**Re: 340 Huntmar Drive – Transportation Impact Assessment
Addendum #1**

The updated Transportation Impact Assessment (TIA) for the proposed hotel development located at 340 Huntmar Drive was submitted in April 2018. Comments have been received on the TIA from the City of Ottawa and this Addendum #1 has been prepared to address these comments. The updated Site Plan is attached.

1 SITE PLAN
A1 SCALE: 1 : 250

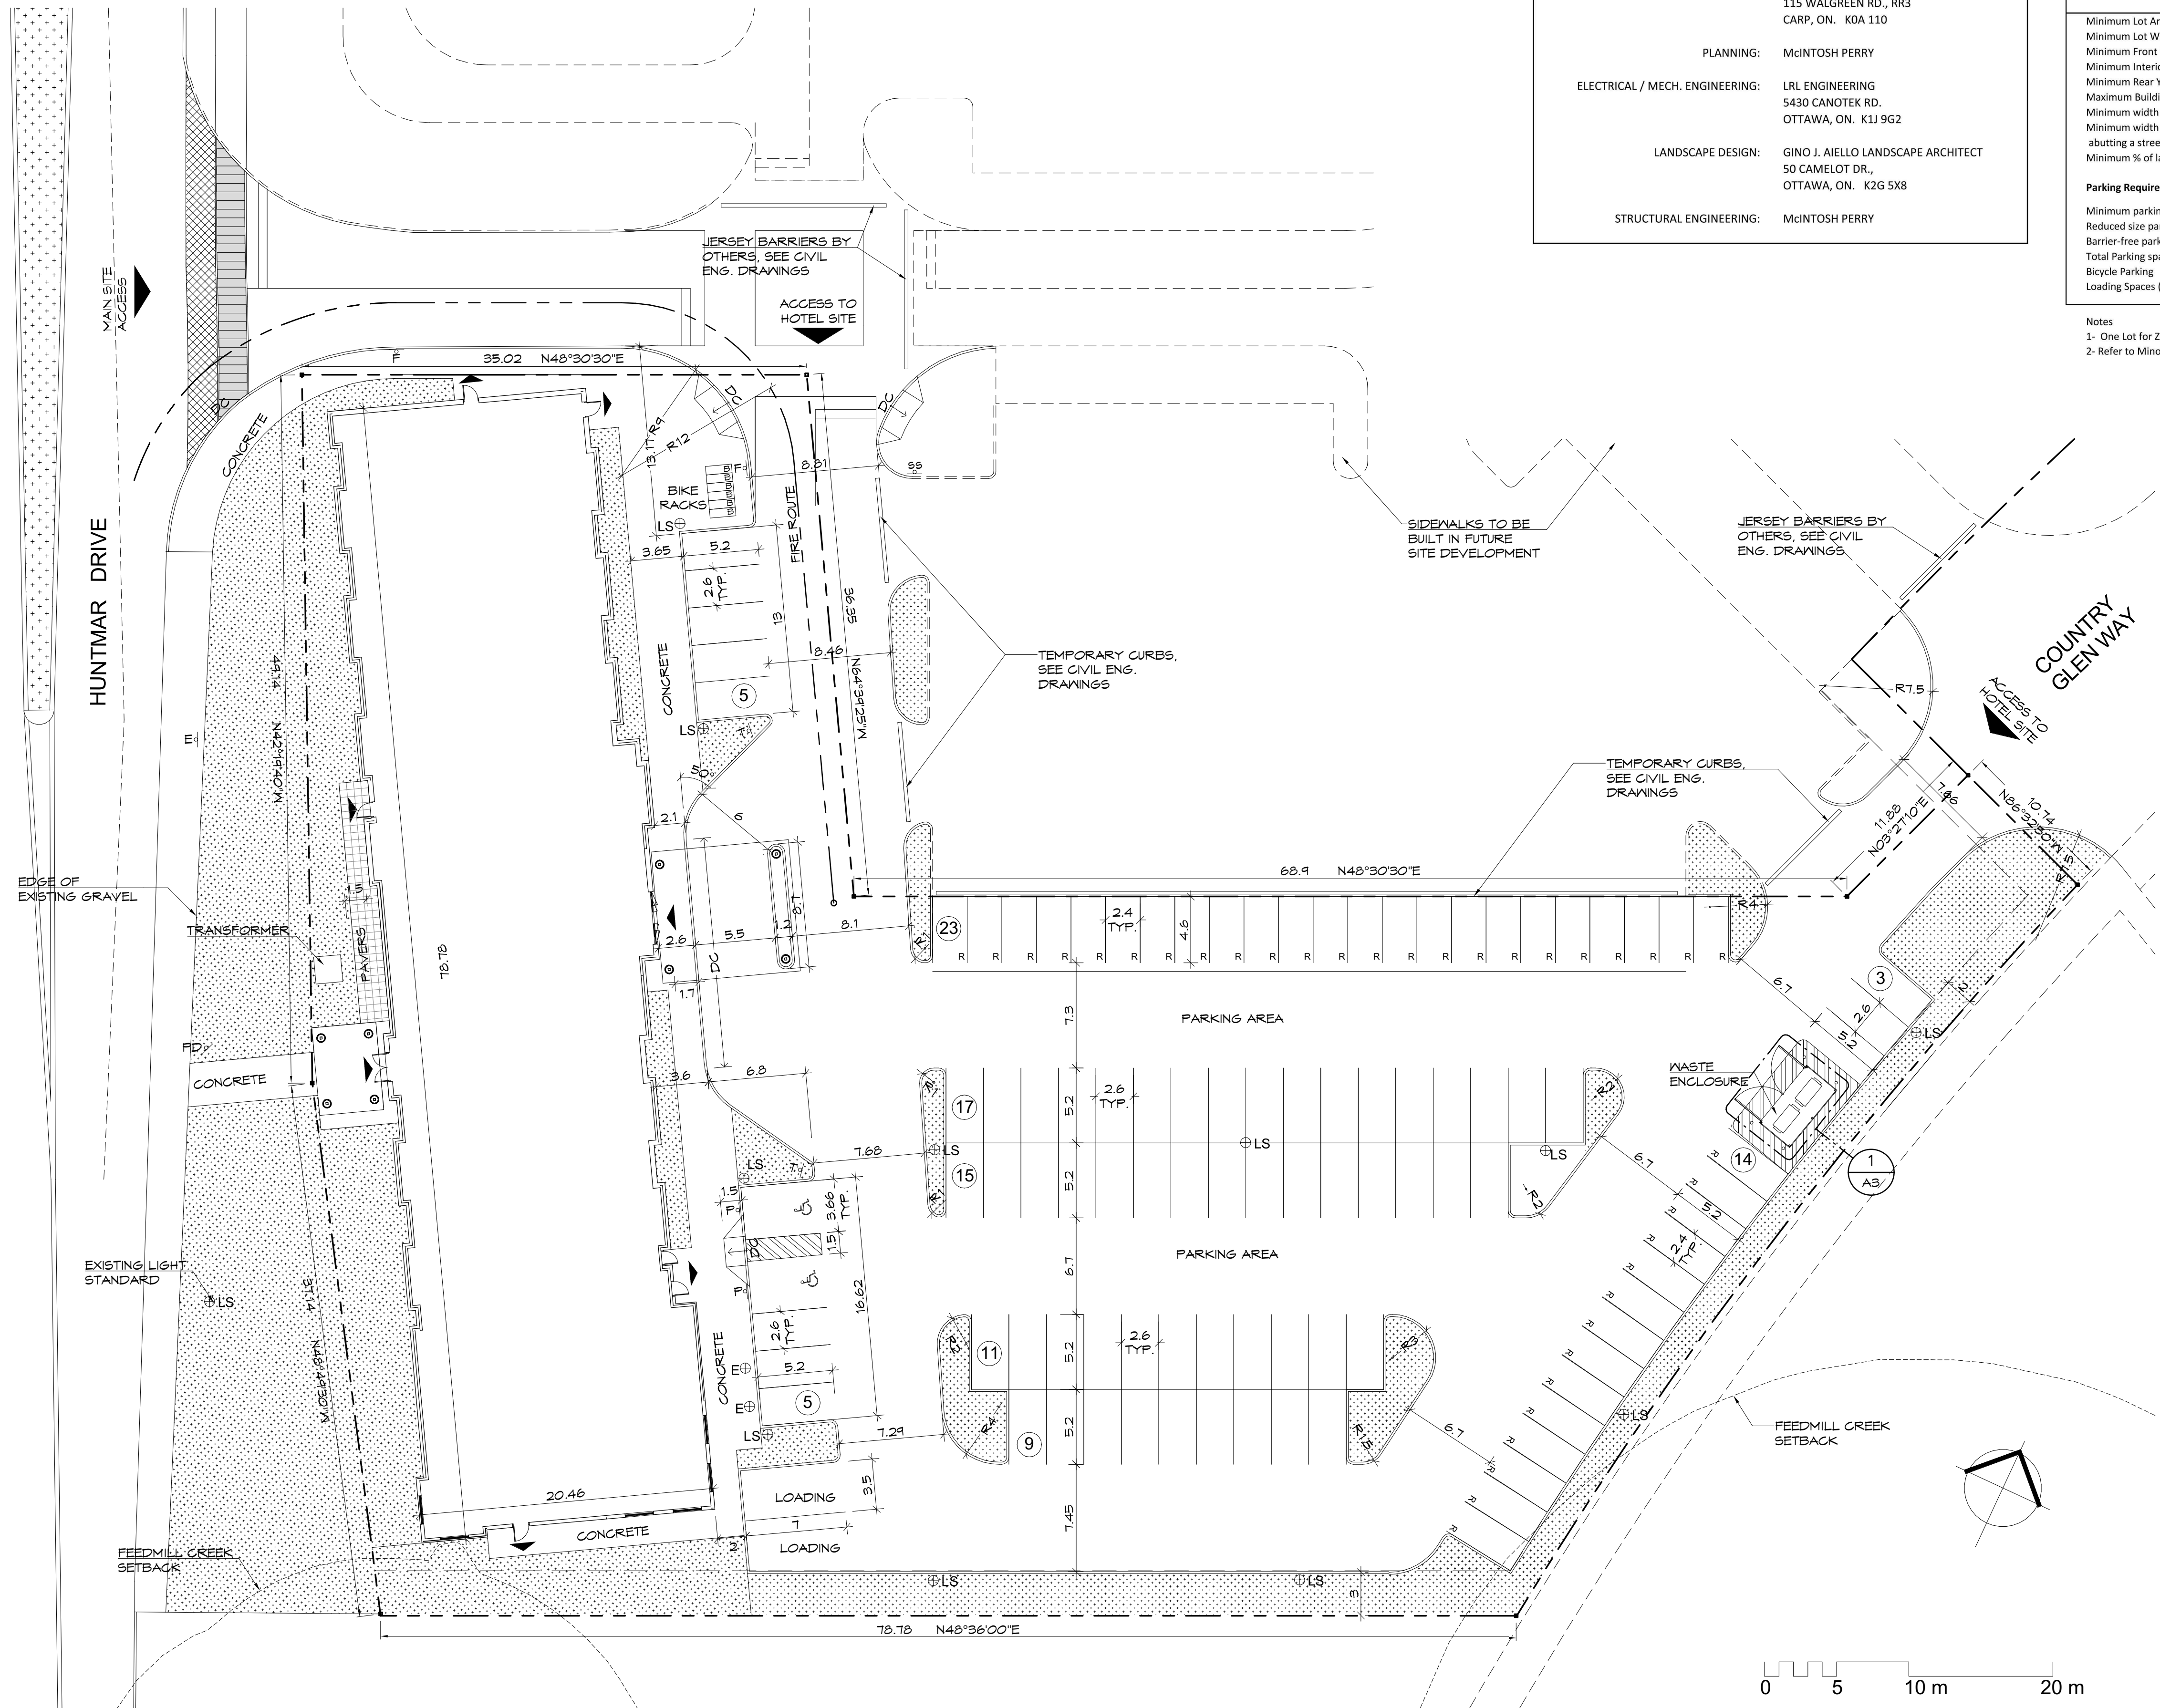
Comment 2: *(Previous Comment) Provide an indication of the transition from existing cycling facilities on Huntmar Drive to/from the proposed cycle track along the frontage. The cycle track and sidewalk should be continuous through the access. Details of this will be required on the site plan and may include thermoplastic paint or other specific treatments to provide visibility. If this work is to be done by other, their design is to be reflected on this site plan and noted as such.*

Comment 3: *(Previous Comment) Review the possibility of providing concrete aprons on both sides of the access to tighten the corner radii for cars and provide a safer crossing for pedestrians.*

Response 2: As shown on the attached Site Plan, green thermoplastic paint is proposed crossing the driveway access along Huntmar Drive.

Response 3: As shown on the attached Site Plan, a curb or paint is proposed in the middle of the driveway to channelize the right-turn into the development and reduce the crossing distance for pedestrians.
